From: Martyn White <Martyn.White@arun.gov.uk>
Sent: 20 December 2019 15:49
To: Planning.Responses <Planning.Responses@arun.gov.uk>
Subject: LU/330/19/PL

LU/330/19/PL

ELEVATIONS

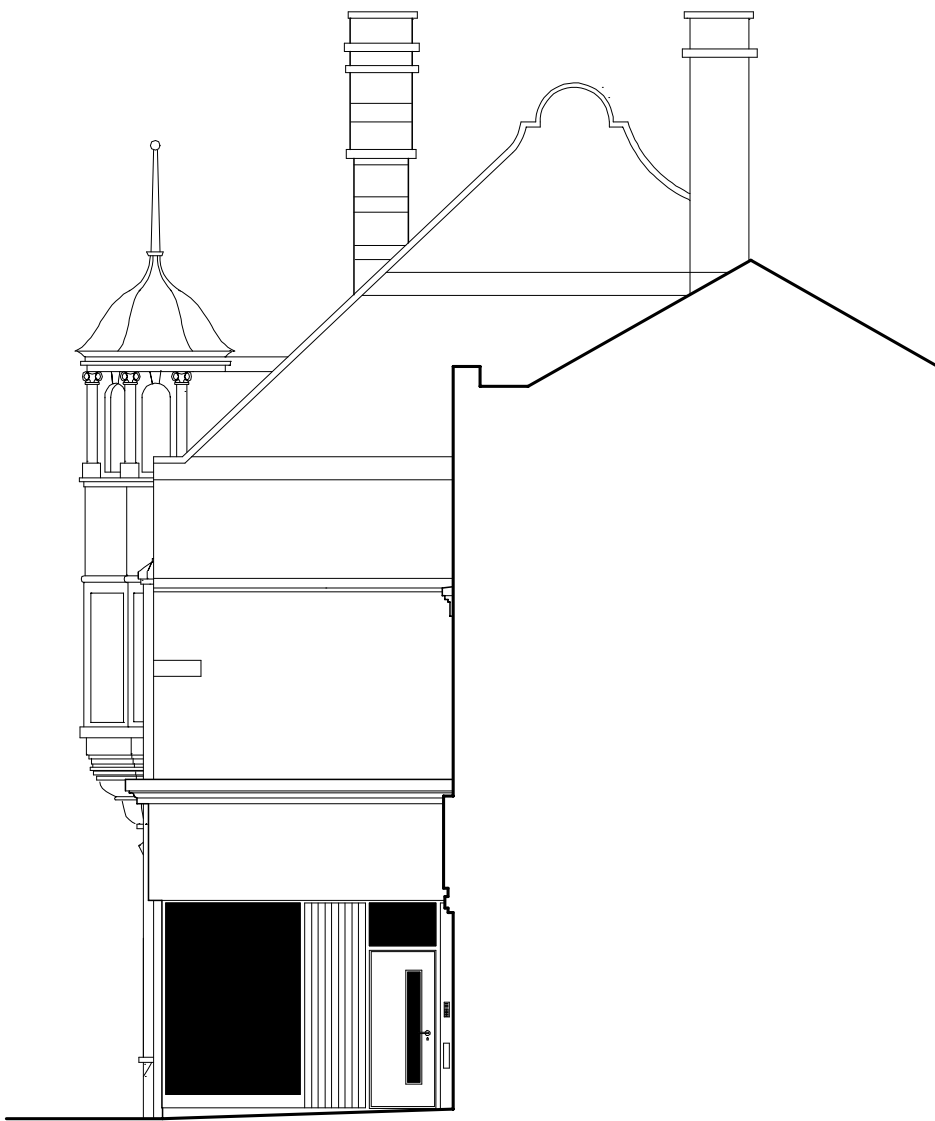
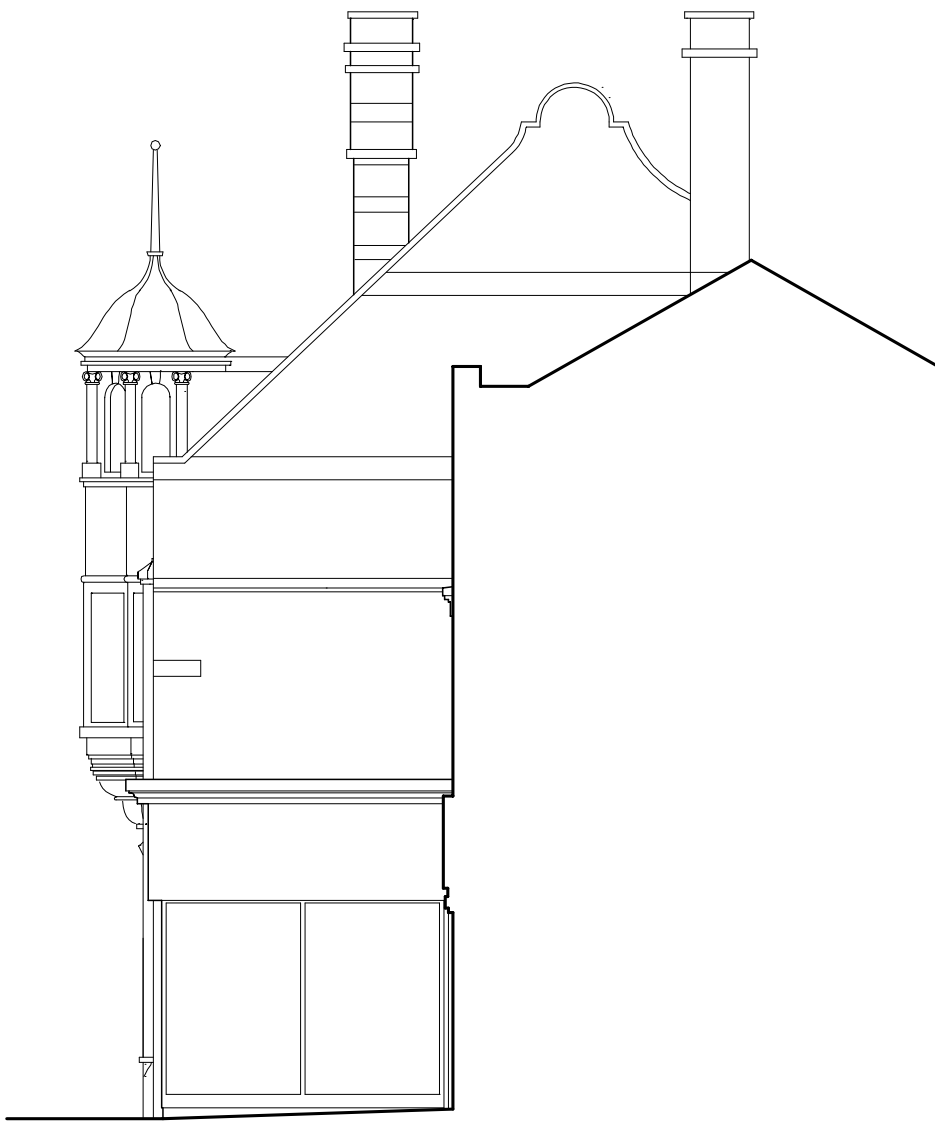
The proposal will alter part of the modern shop front in order to provide an additional door. It is considered that the scale and design of the door is such that it will not harm the non-designated heritage asset. You may wish to request details of the proposed door by way of condition in order to ensure that it is suitable for the building.
